Our Ref T22- 000
Yor Reference: 20032138 Rep 119/Rep 120
13 March 2023

A66 Trans-Pennine Project Scheme 0102 – M6 Junction 40 to Kemplay Bank

I write further to the Hearings of 1 March and 2 March 2023 and the Applicant's Response to Relevant Representations Part 3, page 403/404 - Document 6.5, the Applicant's Response to Written Representations made by Affected Persons at Deadline 1 - Rev 1 submitted at Deadline 2 (document 7.6), Applicant's Responses to the Examining Authority's Written Questions (document 7.240 and the A66 Northern Trans-Pennine Project Applicant's Response to Deadline 3 Submissions (Document 7.27) on behalf of Penrith Properties Limited, BVI registered company 249033, (PPL) in respect of the proposed acquisition of land at Ghyll Mount, Gillian Way Penrith, identified in Developer's Application Document 5.13 as Plot 0102-01-20.

Drawing Number	Project	Originator	Volume
HE565627	- AMY	- HAC	-
S0102	-DR	-CH	-000002
Location		Type	Role Number

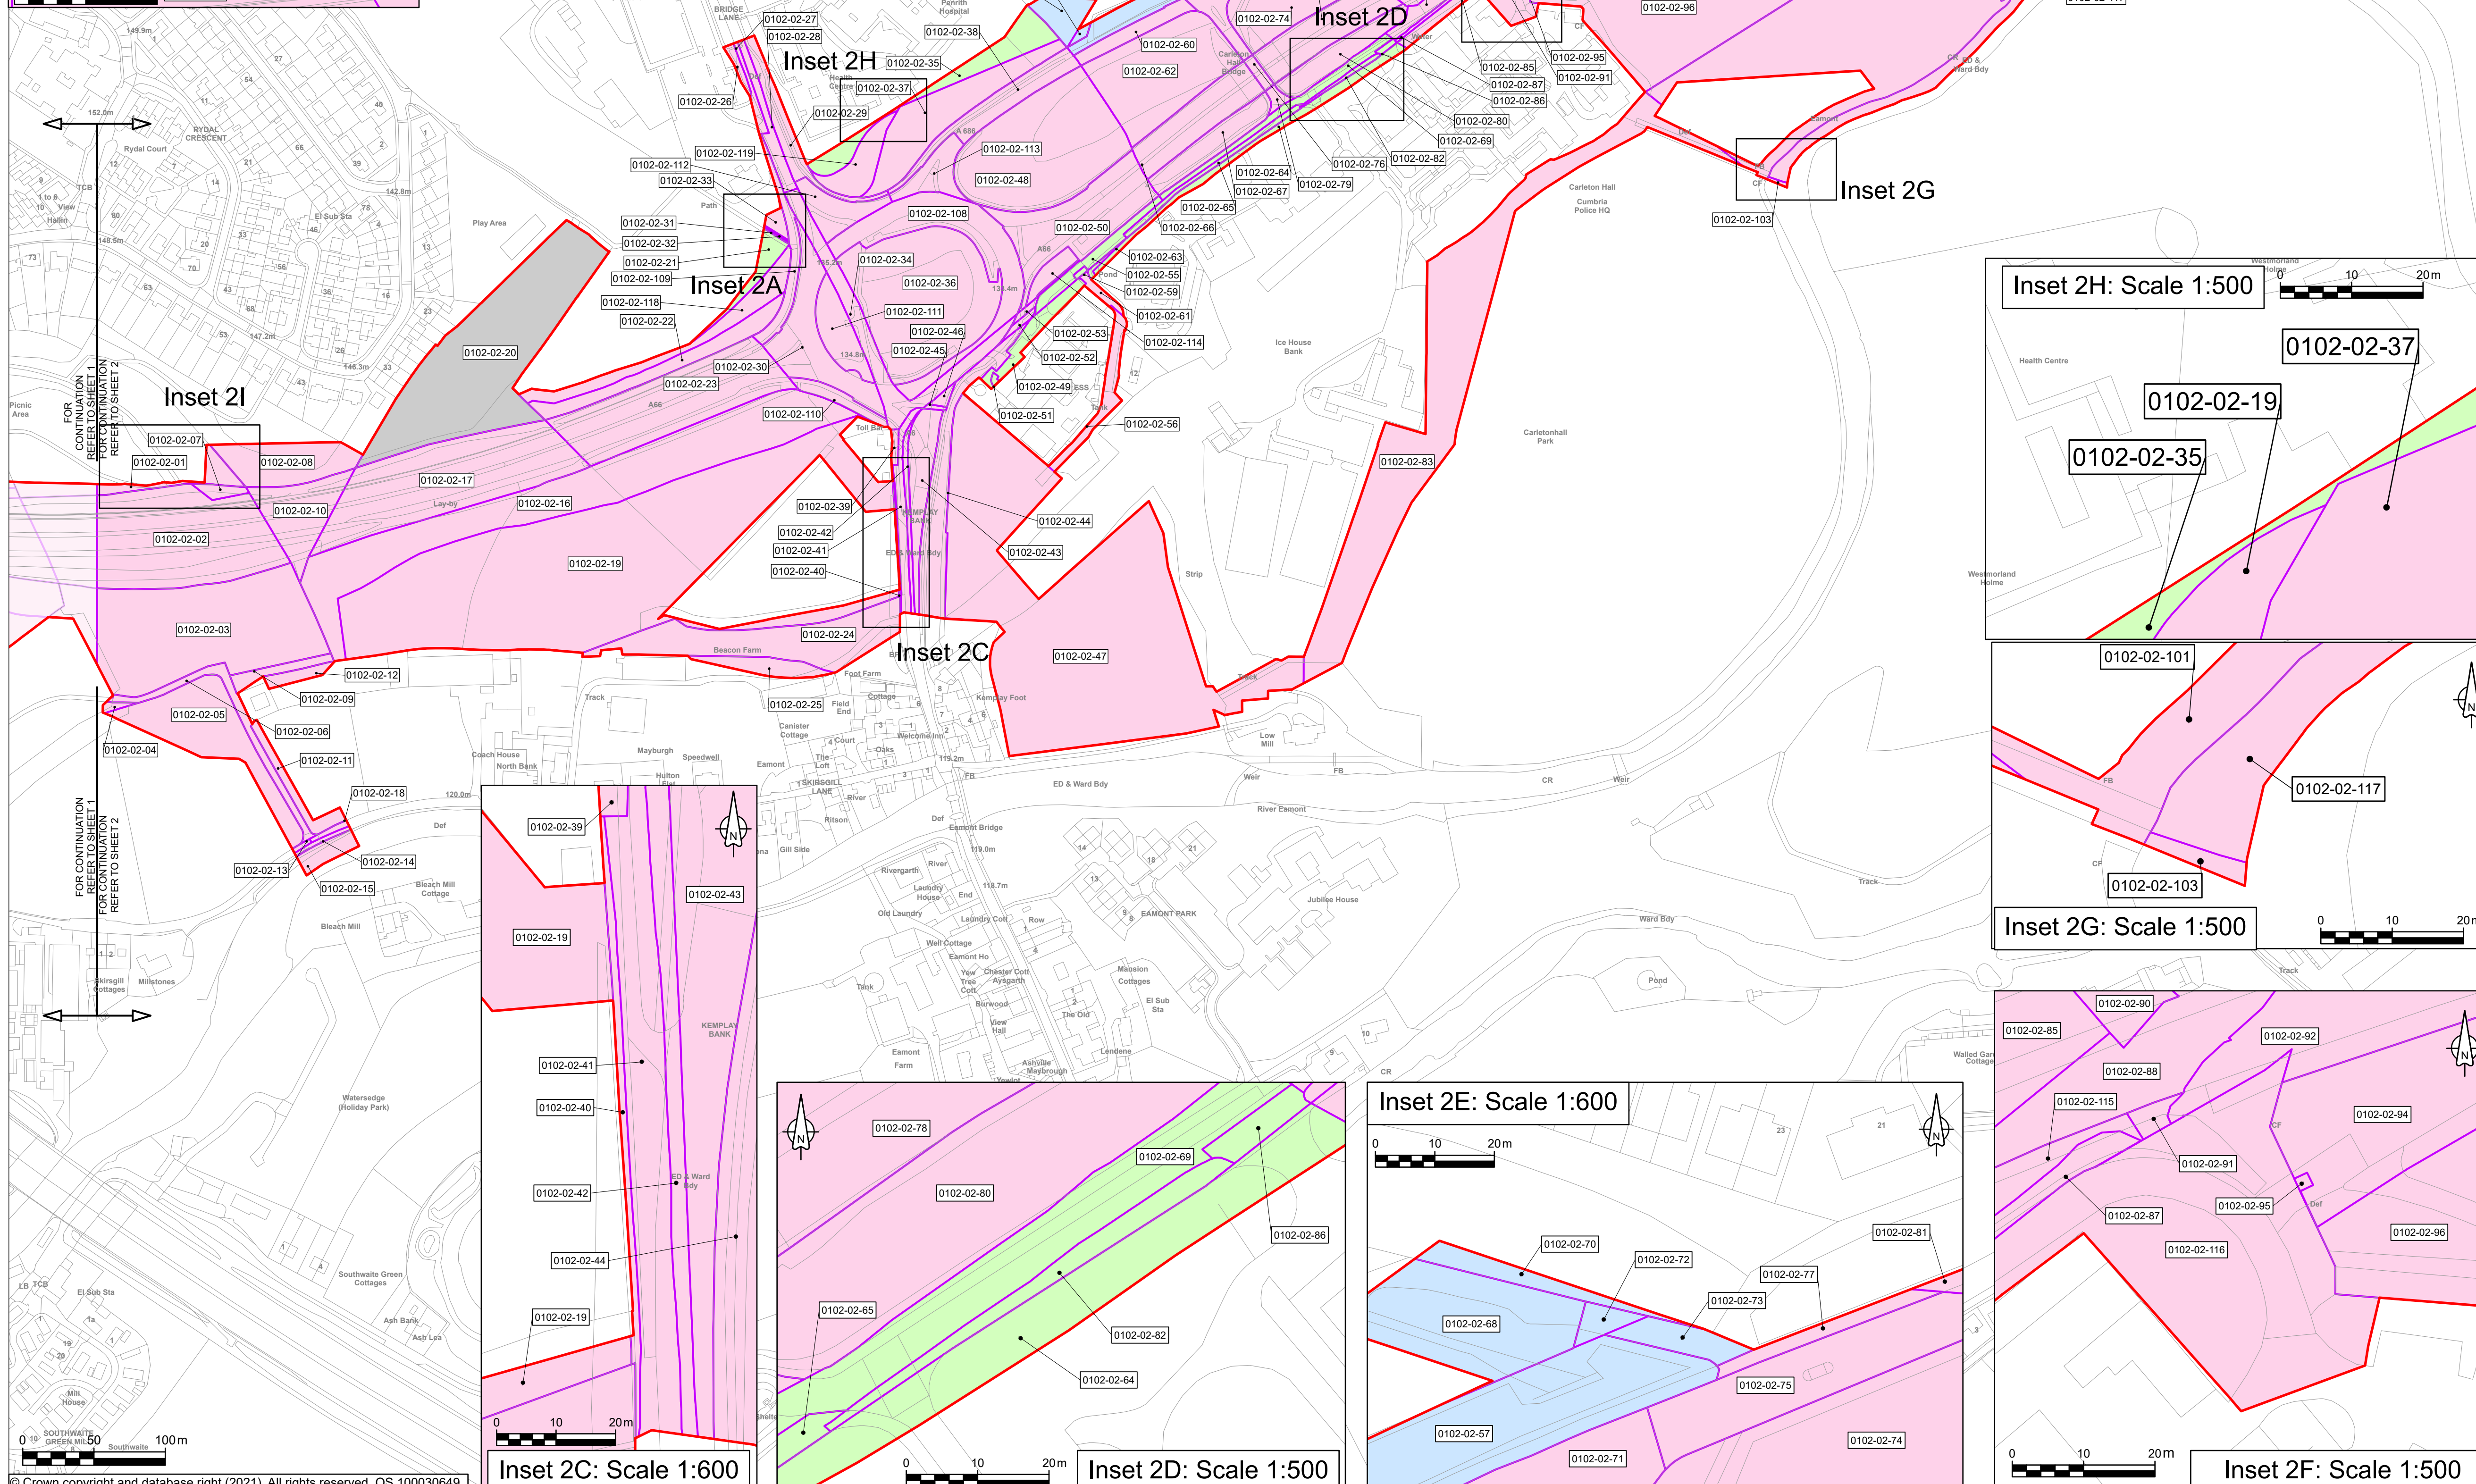
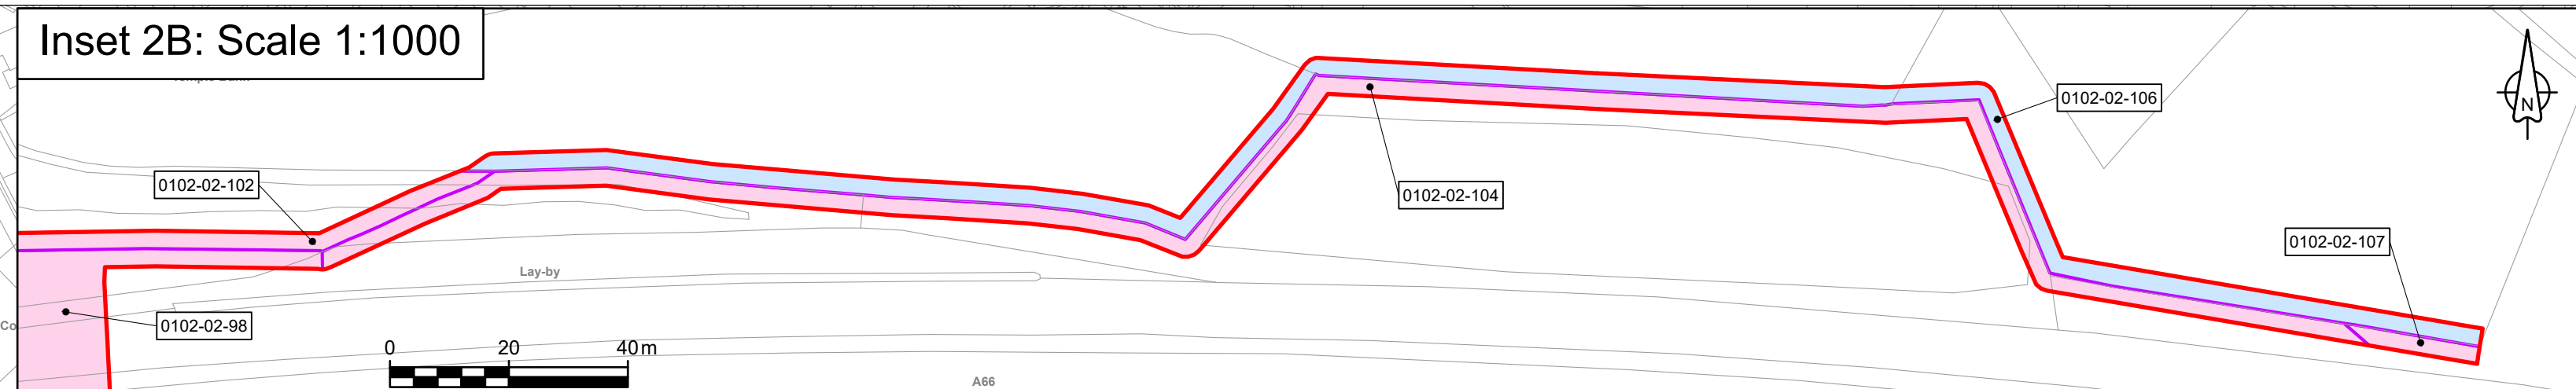
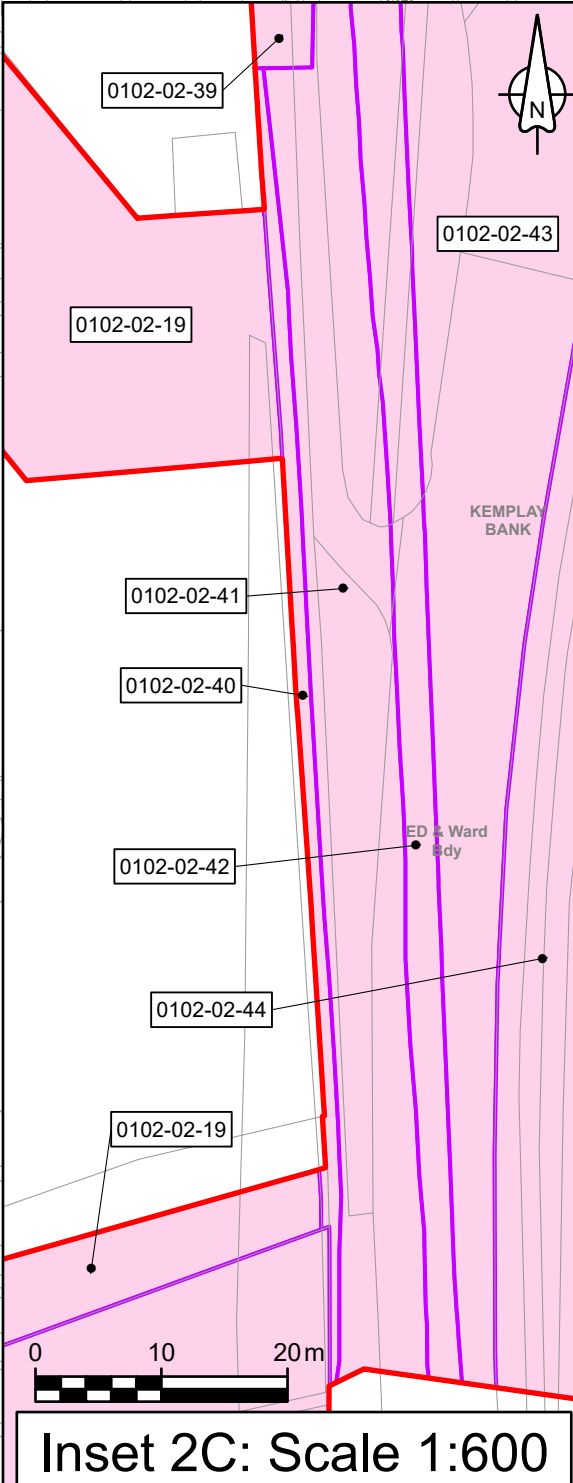
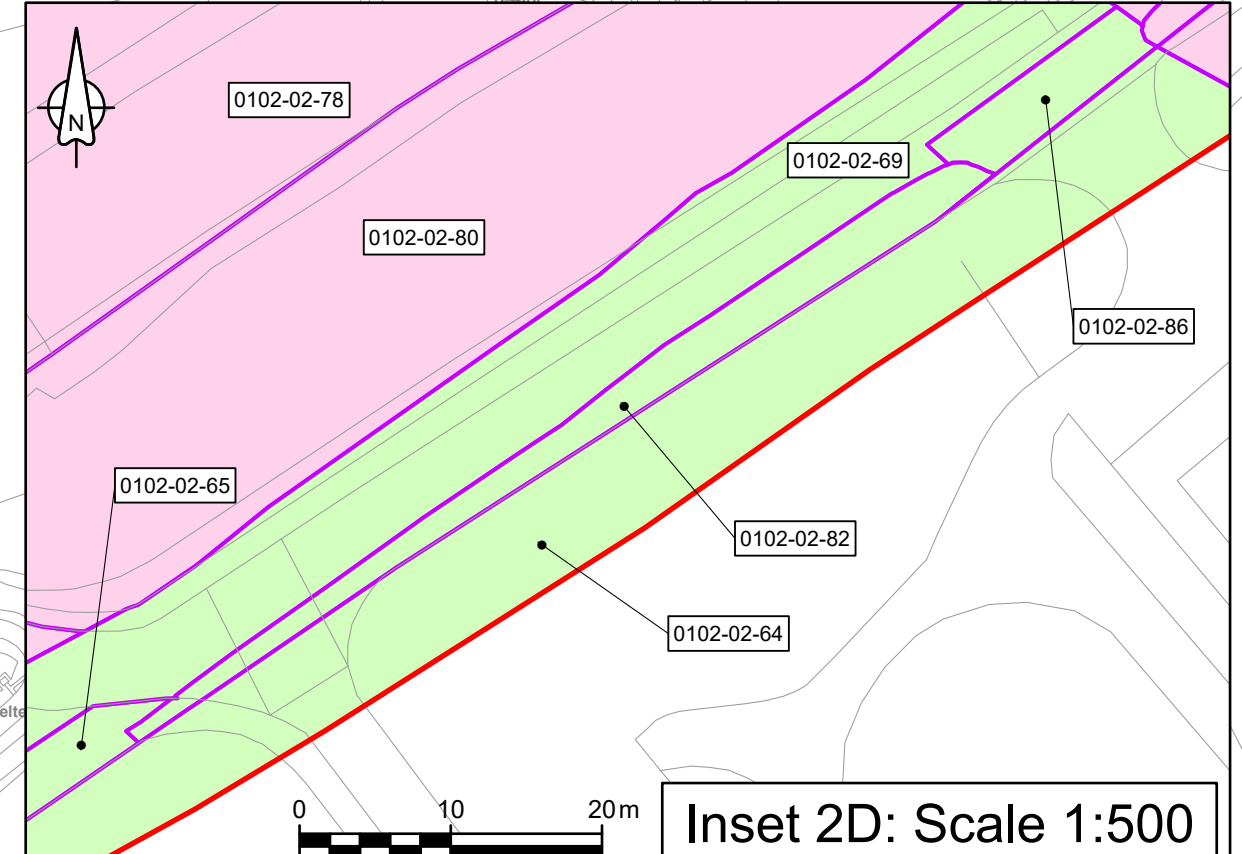
- 1 The applicant has stated that the land at the southern end of PPL land holding may be needed to accommodate minor changes in level associated with adjoining carriageway works to plot 0102-01-20 – works packages 0102-3, 0102-1B and 0102-4.

- b) Assuming the sections are as presented in 5.17, the least change in levels for 0102-1B is noted as being 0.007m (7 mm) and the greatest 0.202m (202 mm). The existing National Highways owned land within which to accommodate this change in levels is between approximately 11 and in excess of 17 metres from kerb of carriageway before any of PPL's land is required. There is no need to acquire additional land to accommodate the minor level changes associated with Works 0102-1B.

- c) Assuming the levels are as presented in 5.17, the least change for works on the A592 (0102-4) are 0m (0 mm) and the greatest 0.390 m (390 mm) the existing verge width with the National Highways ownership is between 11 m and 20 metres to kerb of carriageway within which to accommodate any levels change before land within plot 0102-01-20 is required. There is no need to acquire additional land to accommodate levels changes.

The available land within National Highways existing ownership adjoining 0101-01-20 is sufficient to accommodate the non-motorised user facilities without requiring additional land.

No land from plot 0102-01-20 is required for the removal of existing vegetation on the PPL land or to enable additional planting to take place in the context of the Applicant's road safety standards that maintain distance of planting from the proposed road.

For the sake of clarity PPL do not believe the land identifies as plot 0102-10-20 is required to enable the scheme to be delivered or for future maintenance, for the reasons stated however in so far as it is strictly necessary for the scheme PPL would enable access by agreement to the land to carry out identified works on the strict proviso that it is reinstated with an appropriate boundary treatment in its existing location.
